**Development Review Board 9/7/05 Agenda Item #14
Sketch Plat: Lots 1A, 1B, 6A, 6B, and 6C Block 23
Albuquerque Highlands Subdivision**

**CITY OF ALBUQUERQUE
PLANNING DEPARTMENT
September 7, 2005
DRB Comments**

Project # 1004405 Application # 05-01371

RE: Lots 1 & 2, Block 23, Abq. Highlands/sketch

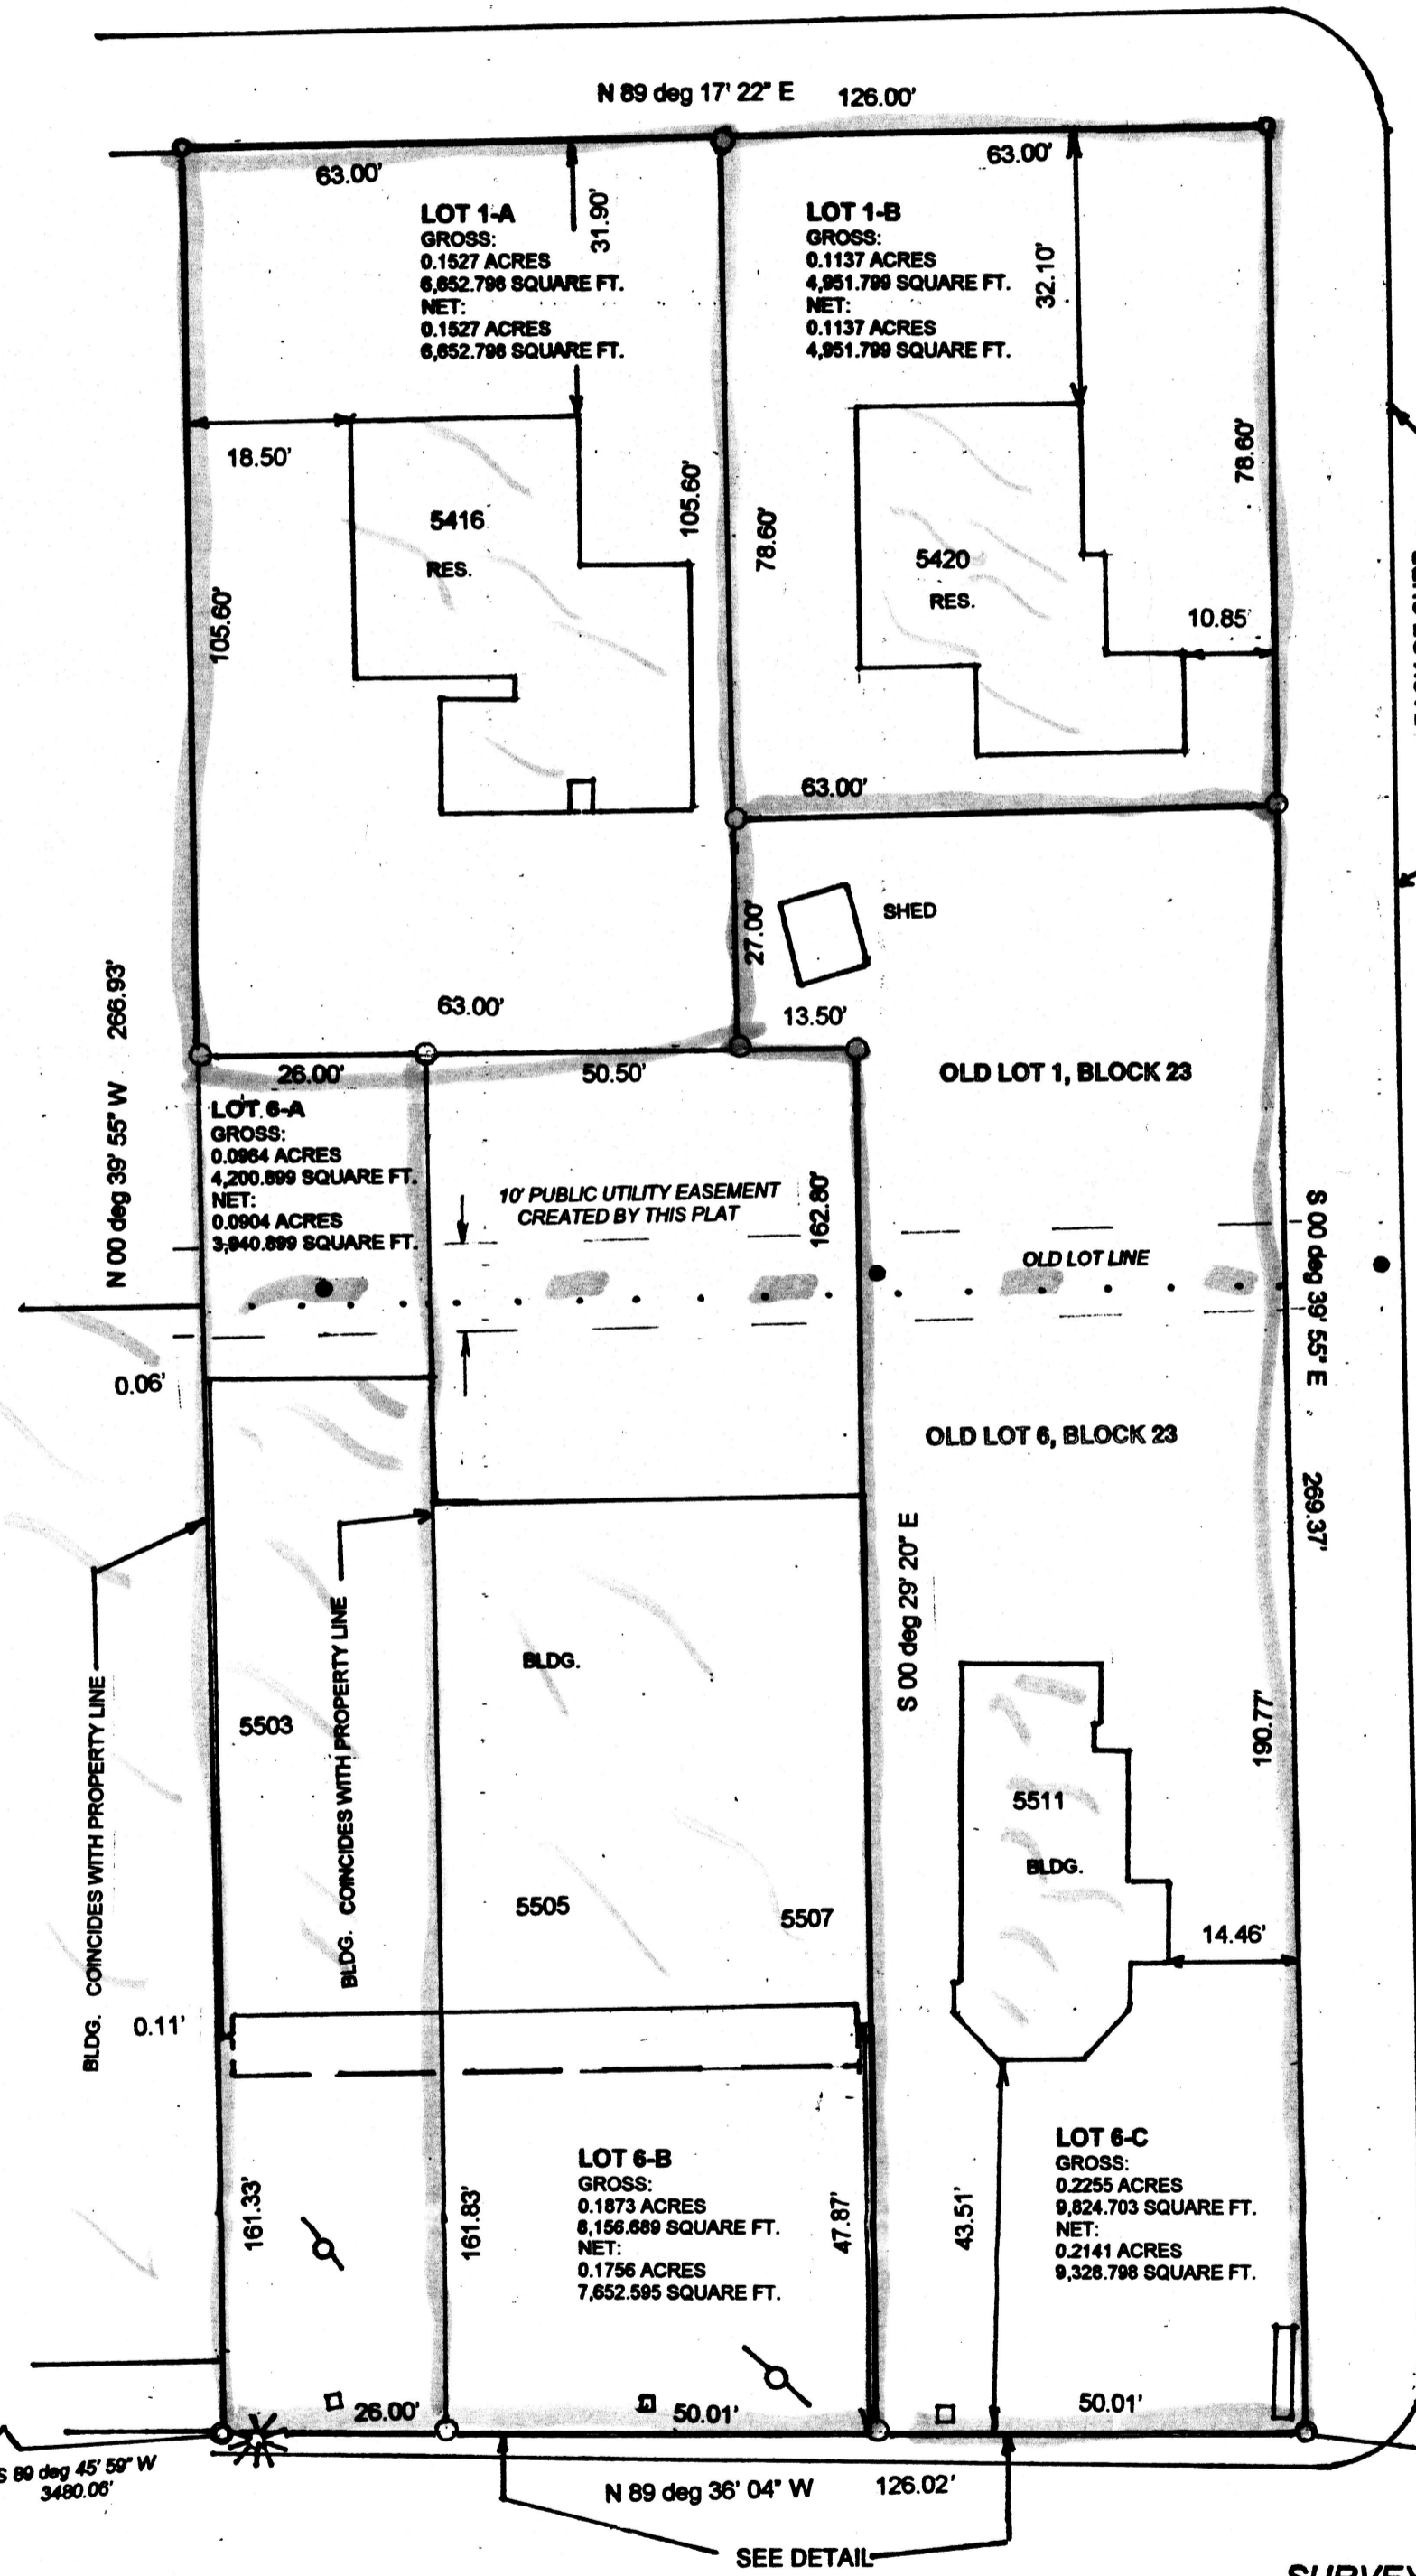
The legal description on this property in question appears to be Lots 1 & 6, not 1 & 2.

Property with different zoning must get rezoned prior to any platting action. Only one zone is allowed per parcel. The zoning according to our records is P, R-1 & C-2. The P zoning appears to be a separate parcel.
